Development Assessment Systems
& Approvals,

PCU049280

Modification Request for the Uni. of Sydney
Abercrombie Precinct Redevelopment
Application No: MP07-0158 MOD3.

Ground Floor Plan
1:200@A1
11.10.13
4001_DA02-D

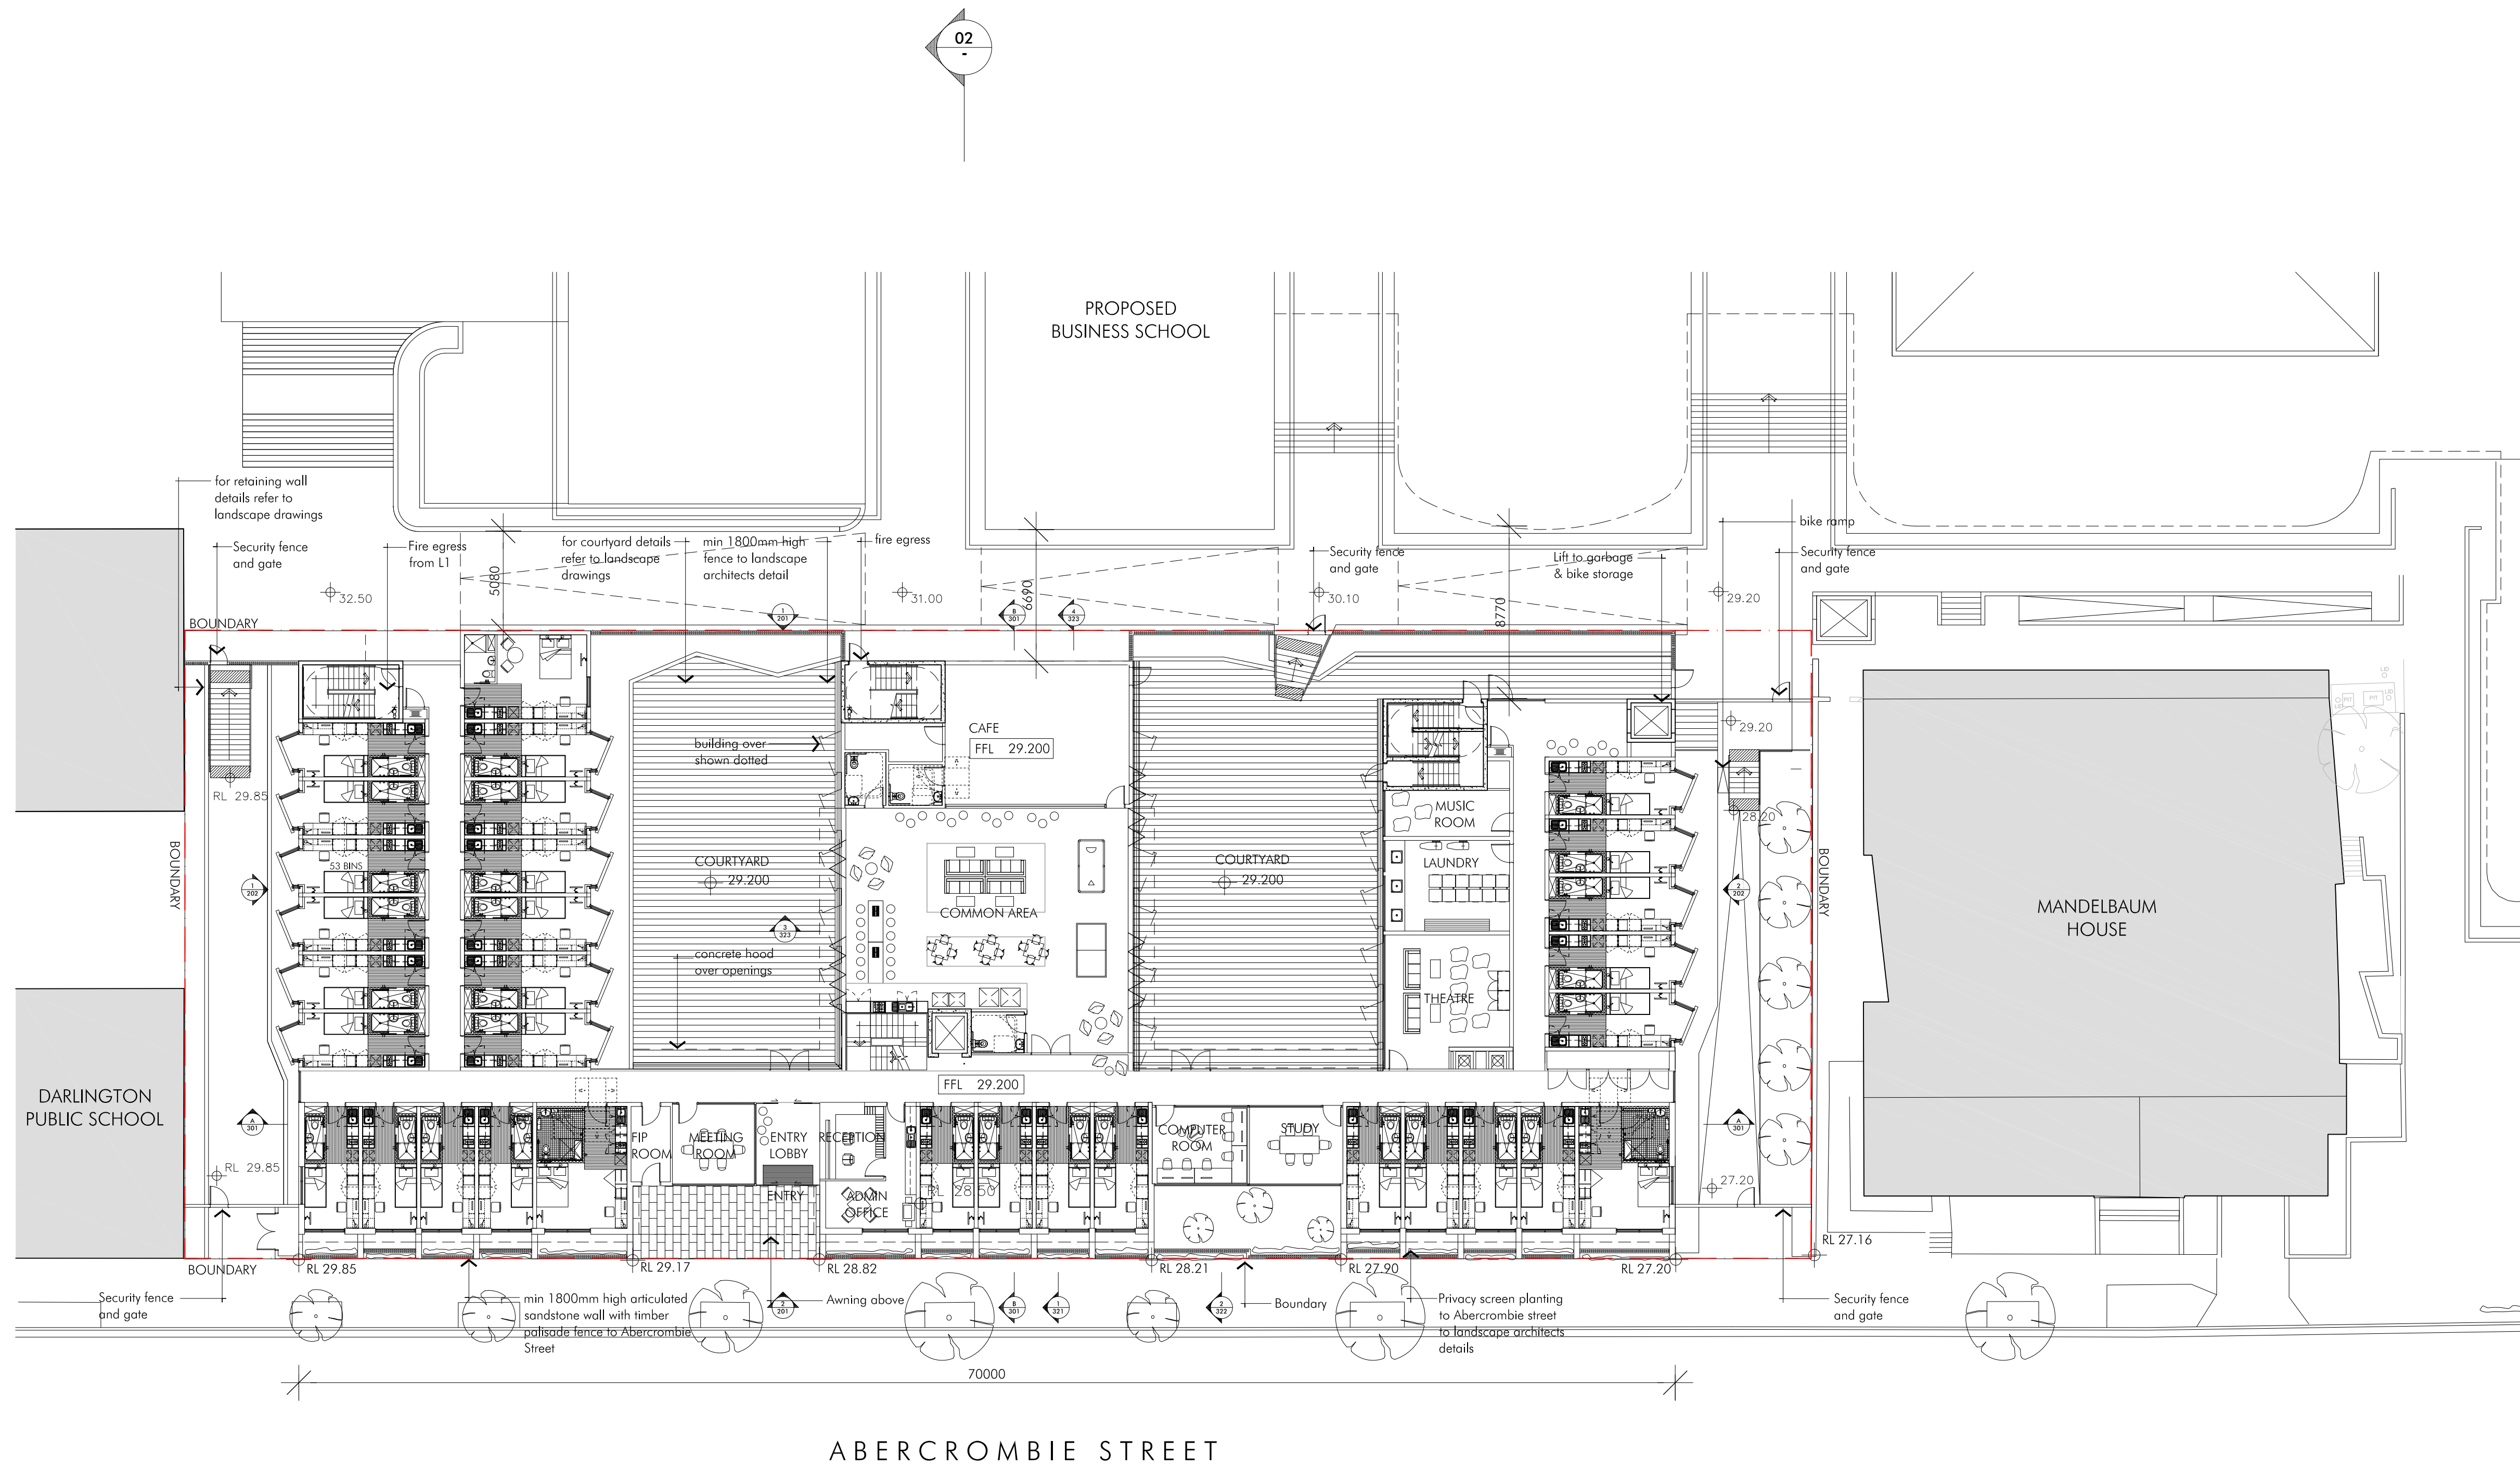
My main objection is that the frontage of the building faces east. For practical reasons (eg temperature control) it should face north.

The current three pods in the design should be separated, so that each pod faces north.

This might enable the Abercrombie St. frontage to be set back from the road further (appeasing the residents opposite)
